Please ask for: Mrs D Johnson
Email: daun.johnson@arun.gov.uk
Telephone: 01903 737762
Our Ref: A/96/21/PL
Your Ref:
Date: 2nd June 2021

Application for Planning Permission

Development: Installation of Portakabin building to be used as additional teaching area. This site is in CIL Zone 2 (Zero Rated) as other development.
Location: Worthing Rugby Club, Beech Tree Childcare Roundstone Lane Angmering BN16 4AX

Title
Proposed Block Plan

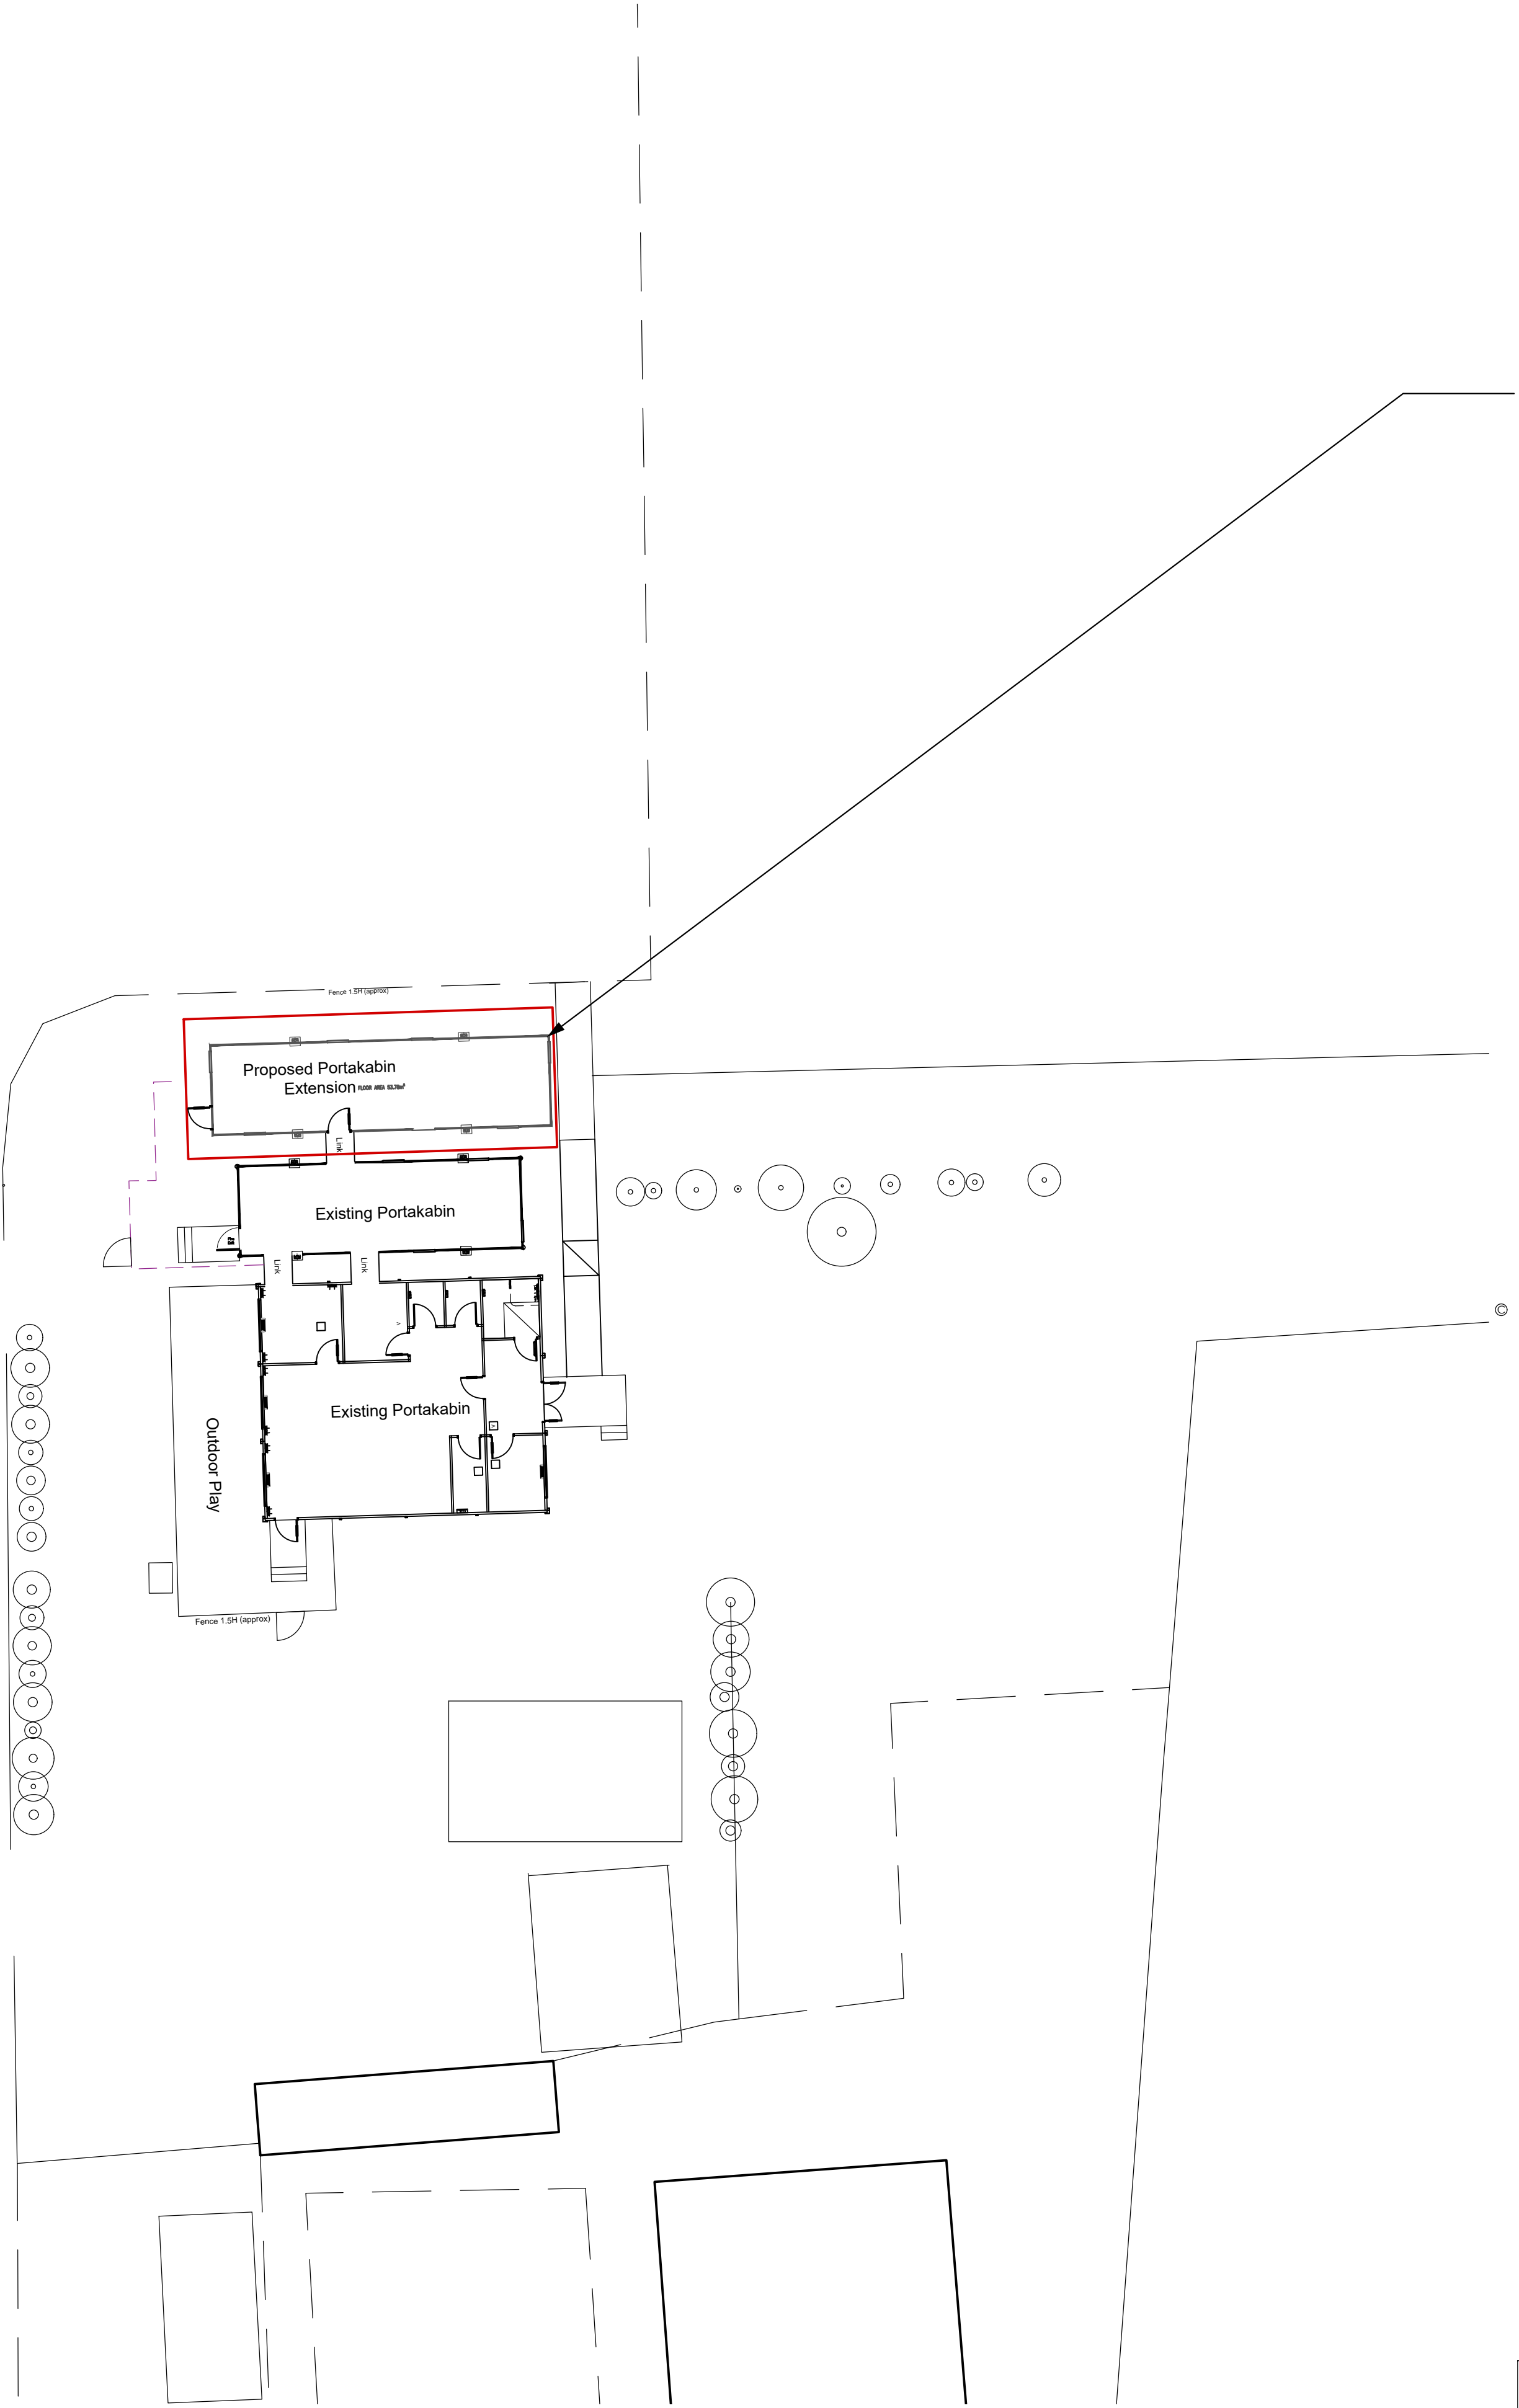
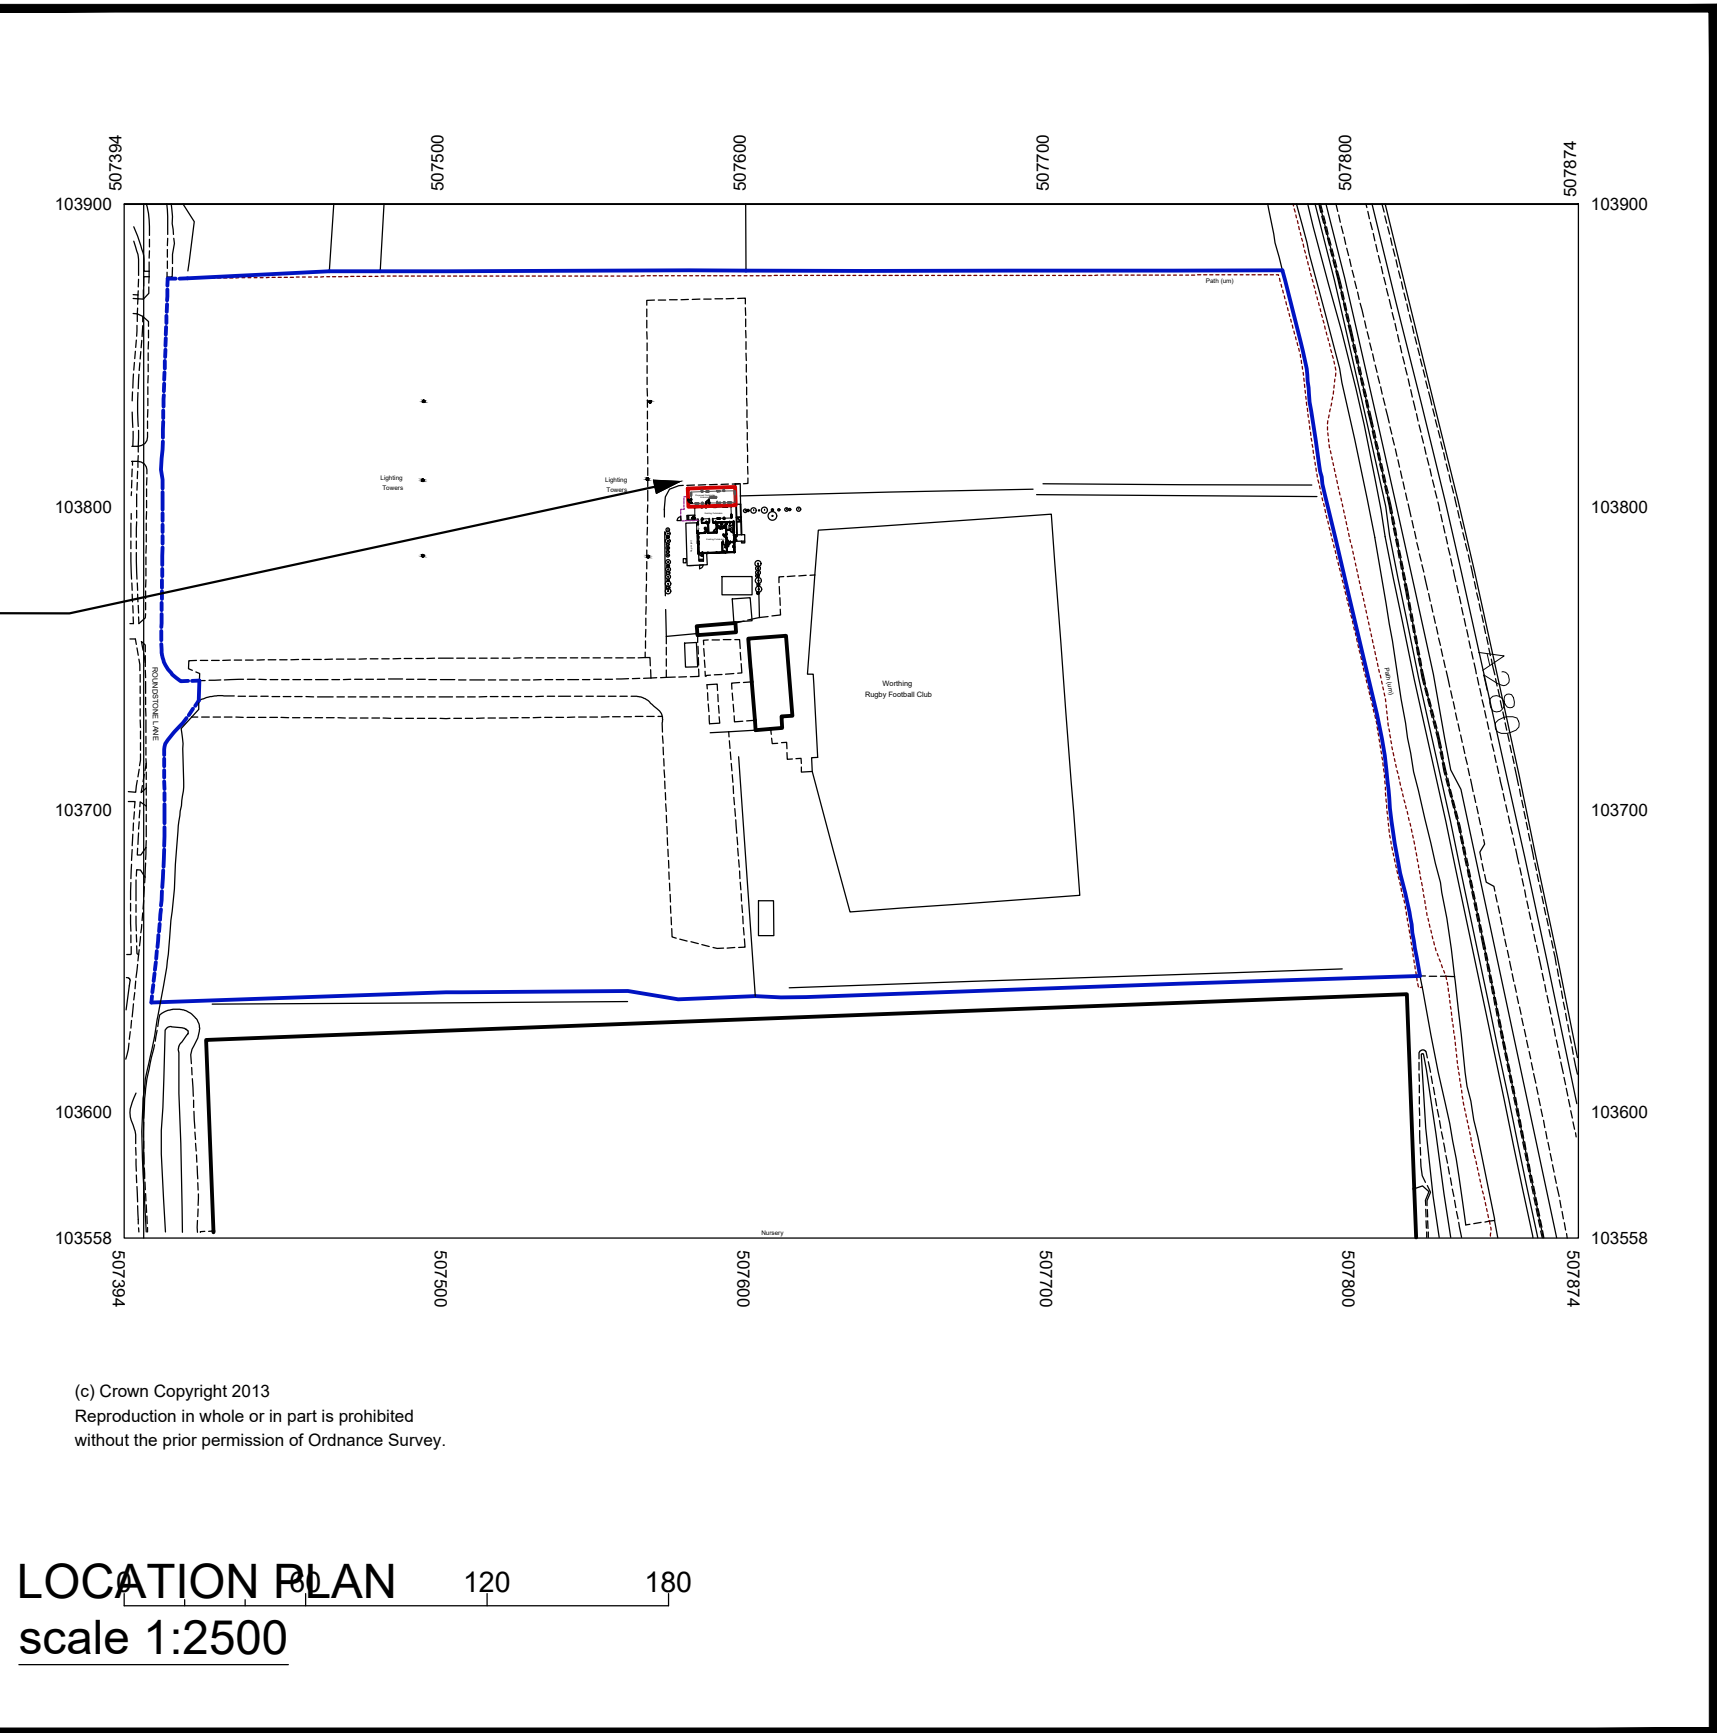
The location and block plans do not scale correctly. Please amend accordingly.
